EN010117: Application by Rampion Extension Limited for the Rampion 2 Offshore Wind Farm

Horsham District Council response to The Examining Authority's Rule 17 Request for further Information issued on 17th July 2024

Deadline 6: HDC Response and Information Requested to the Examining Authority's Rule 17 Request for further Information [PD-017].

OAKENDENE SUBSTATION INDICATIVE LANDSCAPE PLAN

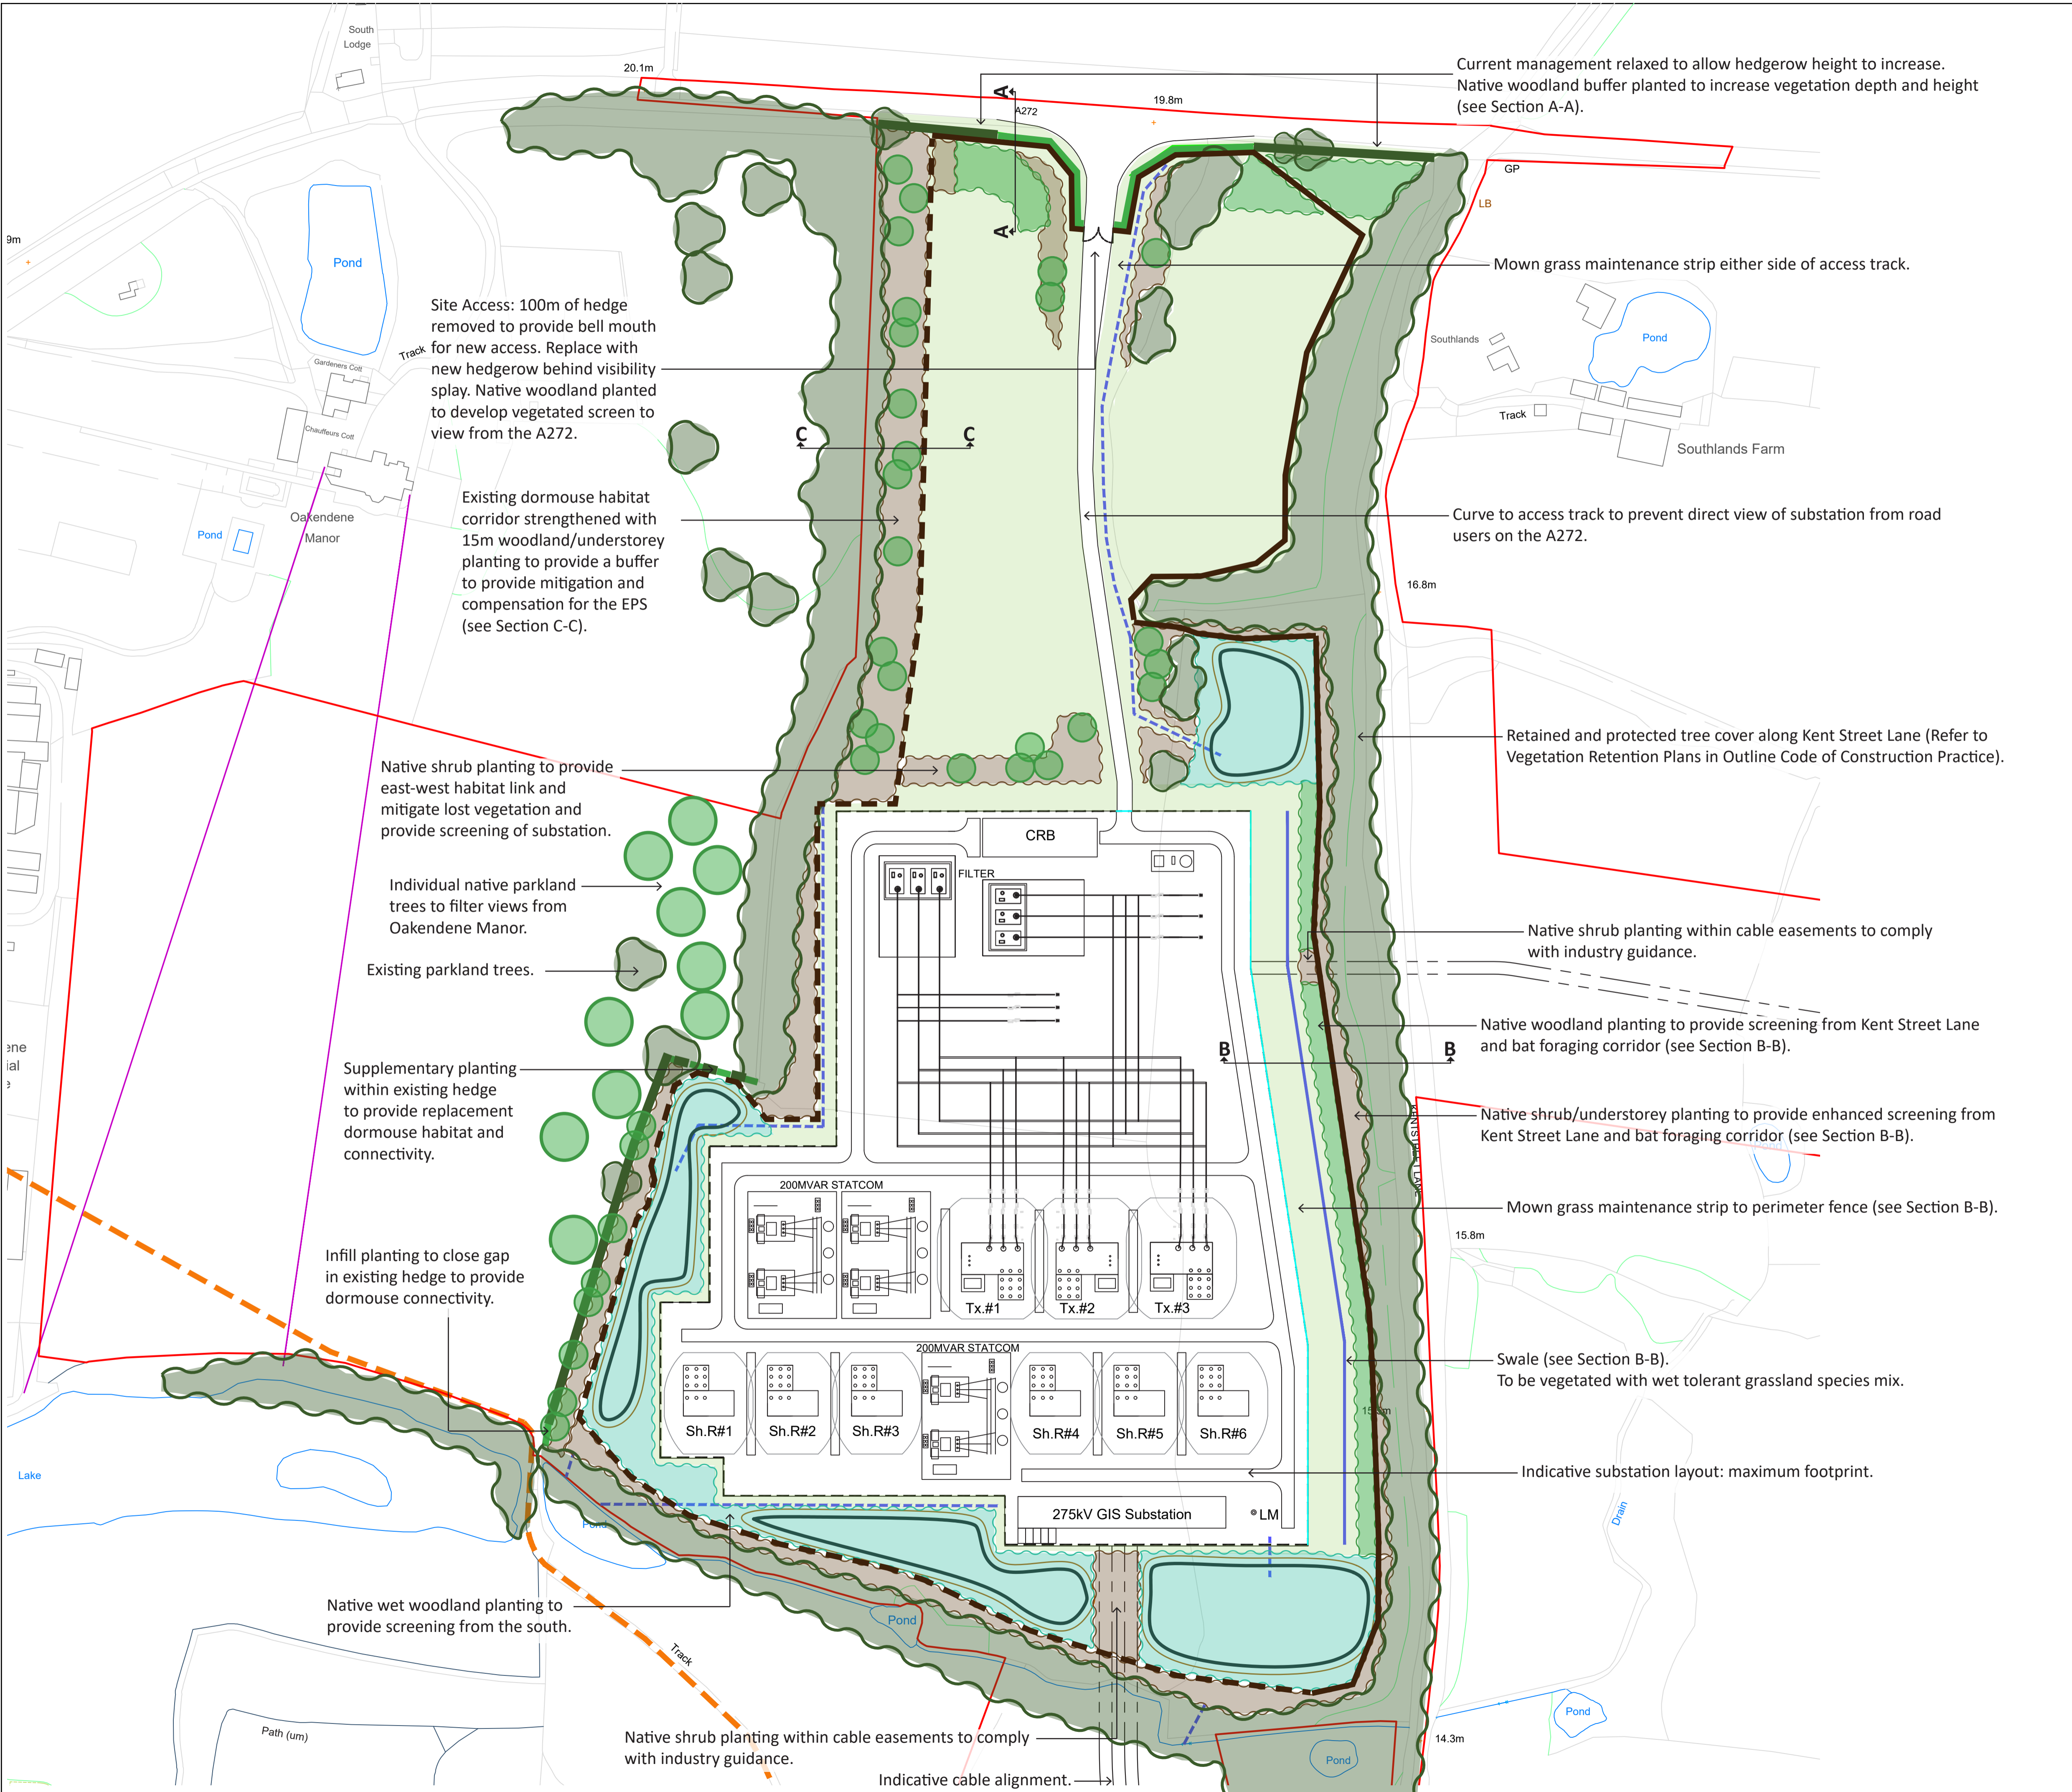
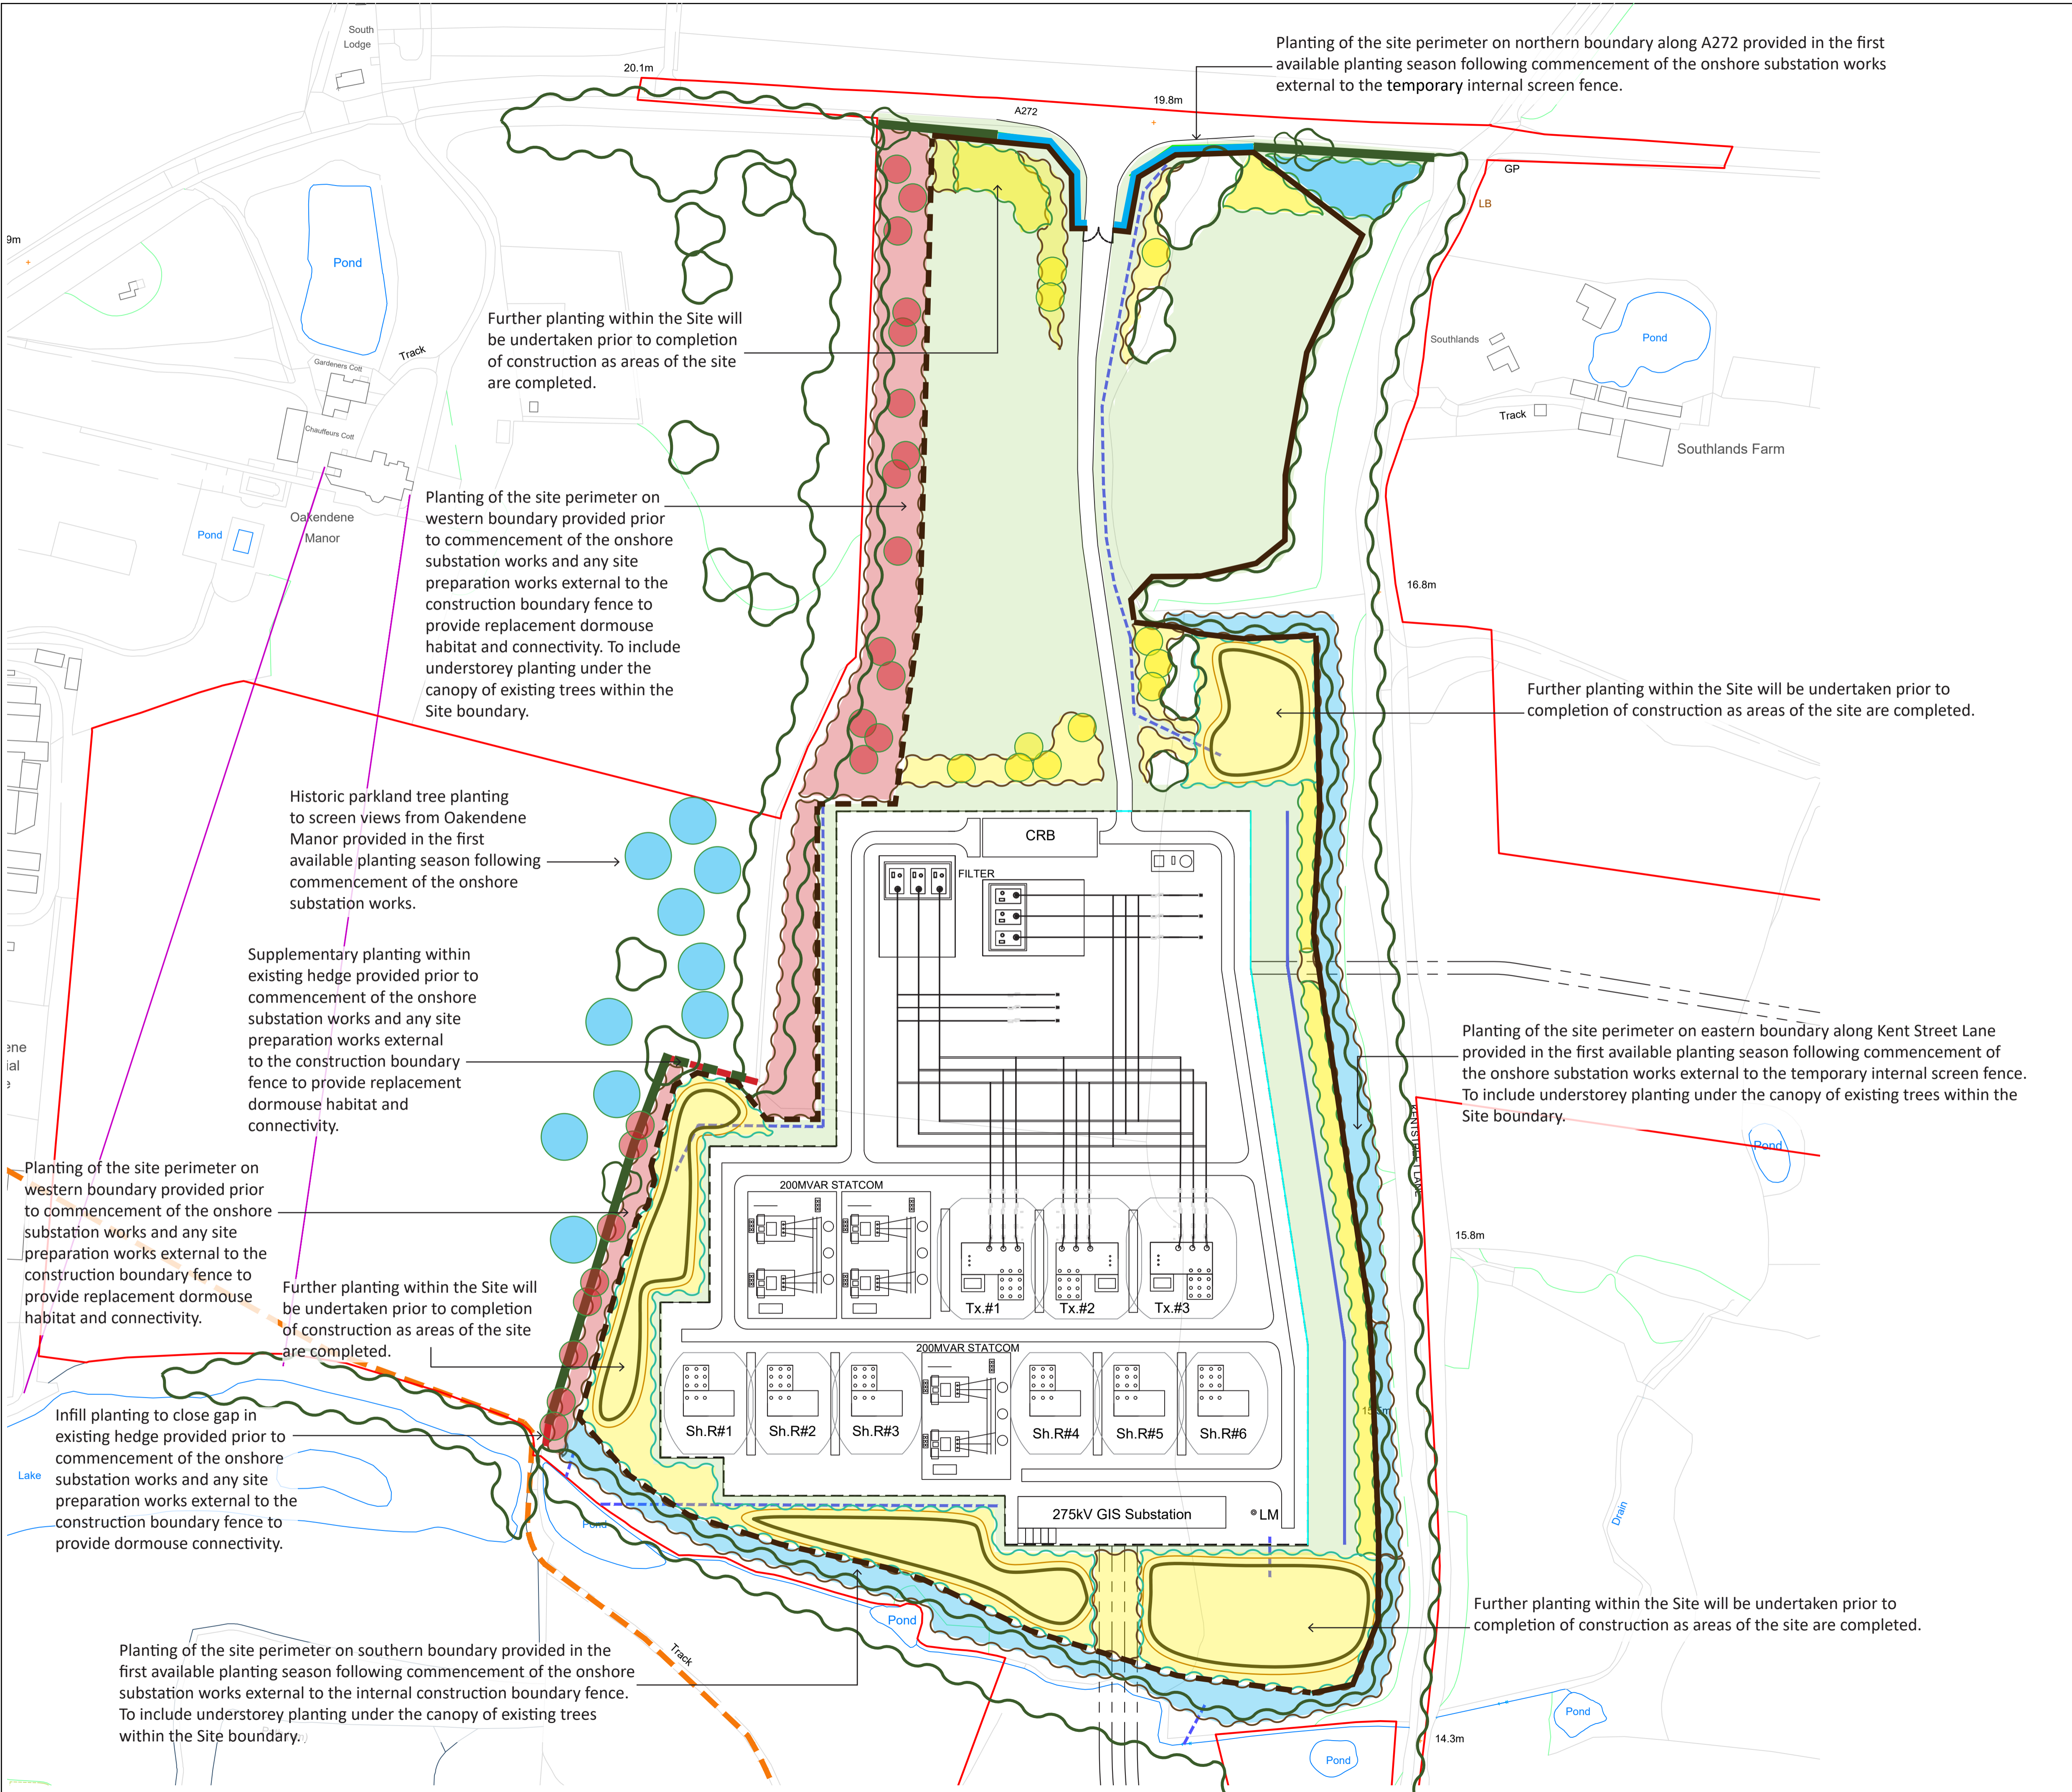
<p>(c) details of vegetation removal, retention and replanting within Work Nos. 16 and 18 and along Kent Street at construction accesses A61 and A64, which shall be consistent with the Outline Vegetation Retention and Removal Plan secured under requirement 40 and the Outline Landscape and Ecology Management Plan secured under requirement 12;</p> <p><i>for the onshore substation have been submitted to and approved in writing by the relevant planning authority following consultation with the <u>local highway authority</u> and West Sussex Fire and Rescue Service and Works comprising Works No. 16 and 18 together with the associated parts of Work No 17, access from Kent Street to Works No. 9 and 19 and use of Work No. 10 at Oakendene, must be carried out in accordance with the approved details.</i></p>	<p>HDC disagrees with the Landscape Assessment Rev B of concerning Minor/Negligible residual effects at Year 10 of Kent Street, where the substation is located. Although the mitigation measures will help integrate the substation, this remains an uncharacteristic feature within the character area and at most it will be a residual Minor Effect. Equally, HDC considers that the loss of the tree line and woods within the area are likely to remain a residual Moderate effect. Or that as result of the temporary loss of vegetation during construction works, the wooded, rural character of Kent Street will be adversely impacted but in time the features will be reinstated.</p> <p>HDC concerns relating to wet woodland feasibility at Oakendene can only be addressed when the finalised landscaping and sustainable drainage documents are provided at the detailed design stage, and HDC encourages amendments to Requirement 8 for this information to be provided within a site-specific plan for Oakendene. HDC would prefer to have reference to SuDs and drainage but appreciate if the ExA's considers this repetition as also covered by work no. 16e) <i>surface water and drainage management measures</i></p> <p>In summary, HDC has consistency advocated in its written submission to the Examination that these issues are addressed by a comprehensive site-specific plan. Therefore, for the reasons above alone but also those made in its submissions throughout the Examination and which remain unresolved, HDC welcomes the ExA's 17th July recommended amendments under DCO Requirement No. 8.</p>
